From: Erin Moore
Sent: Monday, May 05, 2014 10:02 AM
To: Kaycee Hathaway
Subject: RE: Kittitas County Notice to Agencies: BL-14-00009 Homestead View

From: Kaycee Hathaway
Sent: Tuesday, April 22, 2014 2:21 PM
To: Christina Wollman; Josh Hink; Brenda Larsen; Joe Gilbert; Holly Duncan; Erin Moore
Subject: Kittitas County Notice to Agencies: BL-14-00009 Homestead View

EXHIBIT  
 BOUNDARY LINE ADJUSTMENT  
 HOMESTEAD VIEW PLAT  
 LOTS C3 & C4

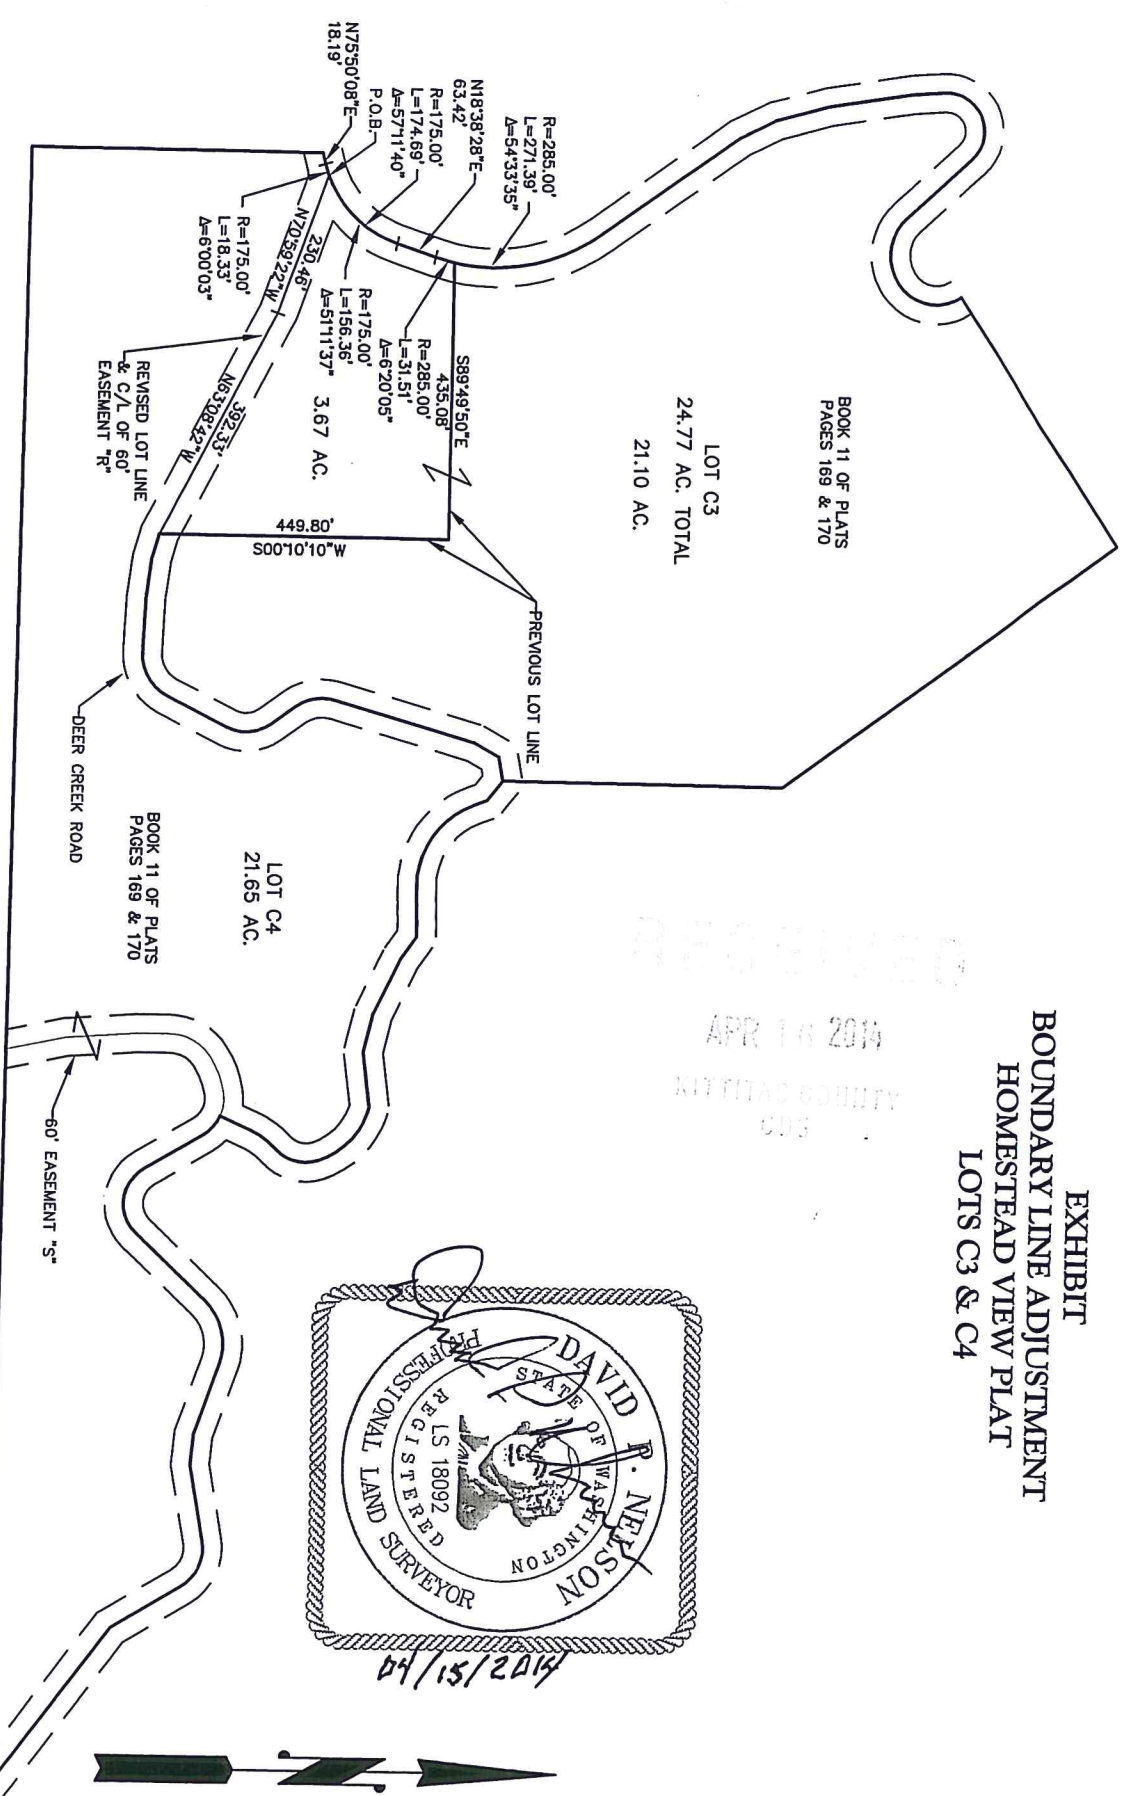
Kaycee,
We need to see septic and well locations on this BL in order to make accurate comments.
